From: lindsey.lucas@hertfordshire.gov.uk
Sent: 24 October 2013 12:02
To: Planning
Subject: Planning application S6/2013/1916/FP - TESCO EXPRESS 59 Station Road

District ref: S6/2013/1916/FP
HCC ref: WH/328/2013 (Amended)
HCC received: 10/10/2013
Area manager: James Dale
Case officer: Lindsey Lucas

Erection of 2x cycle stands and realignment to existing car park

Figure 1 – Proposed External Works

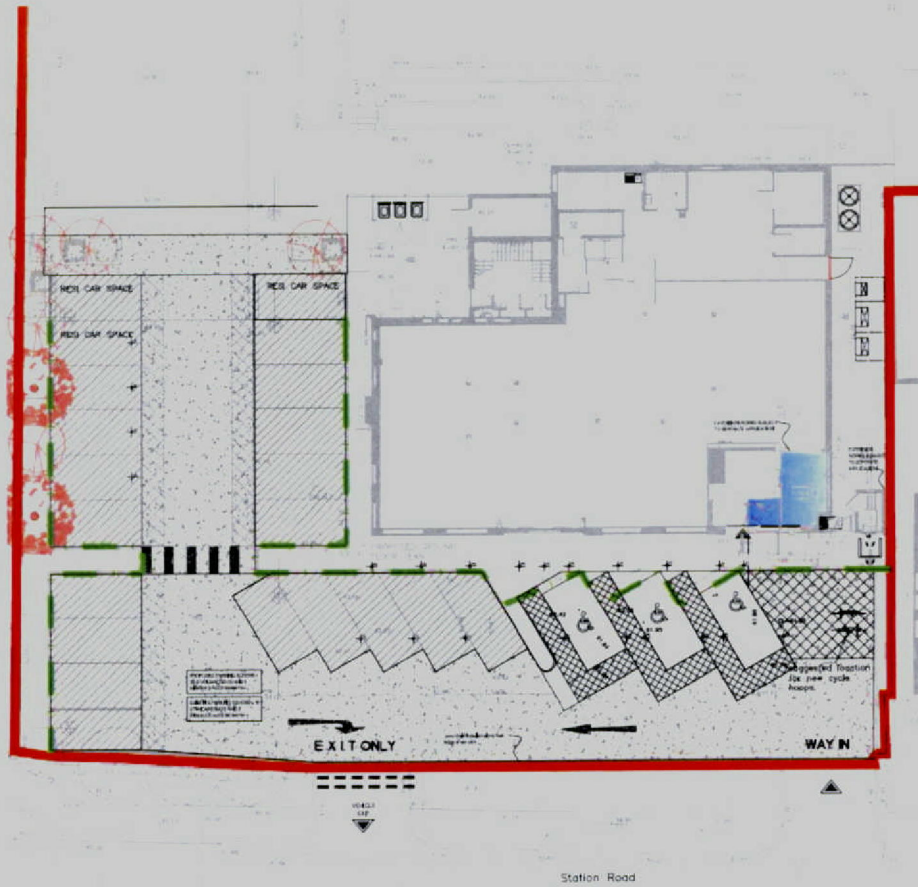
Although this application relates to the internal re-arrangement of the parking bays and cycle racks, the Highway Authority is concerned that the re-arrangements of the car parking spaces will make manoeuvring inside the car park very difficult and could result with vehicles having to wait on the highway before entering the site. Currently vehicles can enter and leave the site at the western access and enter at the eastern access. The eastern access also serves the service area and can be blocked by service vehicles. The proposals make the western access an exit only and the eastern access the only entrance. Vehicles will not be able to enter when a service vehicle is on the site and would queue back onto the highway. The plans also show the parking spaces being relocated and the re-arrangement moves the parking spaces further to the west into the current aisle at the western side of the car park. The end space will reduce the aisle width to less than 6m meaning that vehicles will be unable to manoeuvre in and out of the 4 bays in the south western corner of the car park. It will also make it difficult for cars to pass each other at the access. The difficulties in manoeuvring could result in cars having to wait on the highway before being able to enter the car park close to the pedestrian crossing point and affecting the flow of traffic on Station Road. The proposed changes to the car park layout appear to be to enable some spaces to be converted to disabled bays. Although the LPA are the parking authority and will determine the appropriate level of parking, the Highway Authority considers that it would be better to maintain two way access and manoeuvring space

and loss two car parking spaces, rather than to try and fit the spaces in. Alternative parking is available in car parks in the locality and parking restrictions will prevent overspill onto the carriageway.

With regard to the cycle stands, the proposed location will reduce width of the pedestrian access to the rear of the site and the LPA may have a view on this.
